DRB Application No.: 07DRB-00421 (P&F)
Project Name MESA GRANDE
Agent: WAYJOHN SURVEYING

15. **Project # 1005478**
07DRB-00421 Minor-Prelim&Final Plat
Approval

CITY OF ALBUQUERQUE
PLANNING DEPARTMENT
April 11, 2007
DRB Comments

PLAT OF
LOTS 2-A AND 19-A
BLOCK 15
MESA GRANDE ADDITION

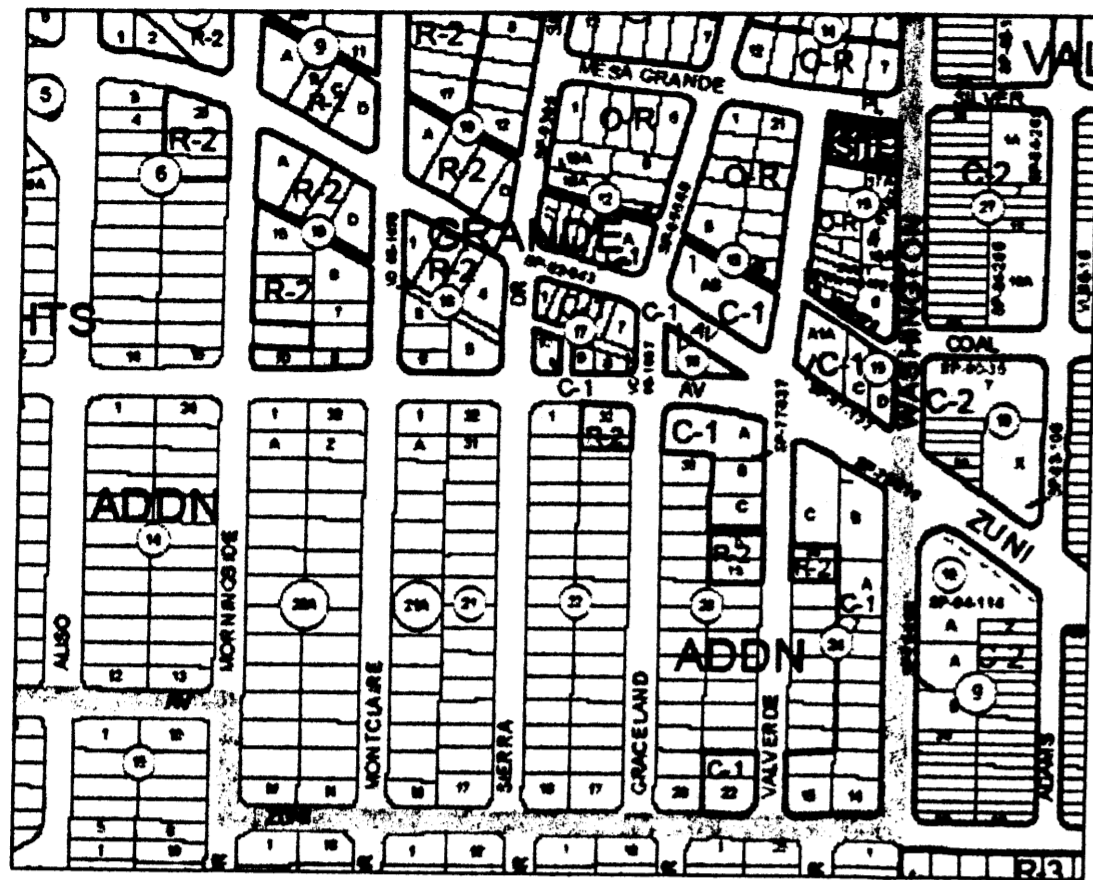
The property lies within the Nob Hill Sector Plan area. Therefore, the zoning is SU2-OR. Please correct on the plat.
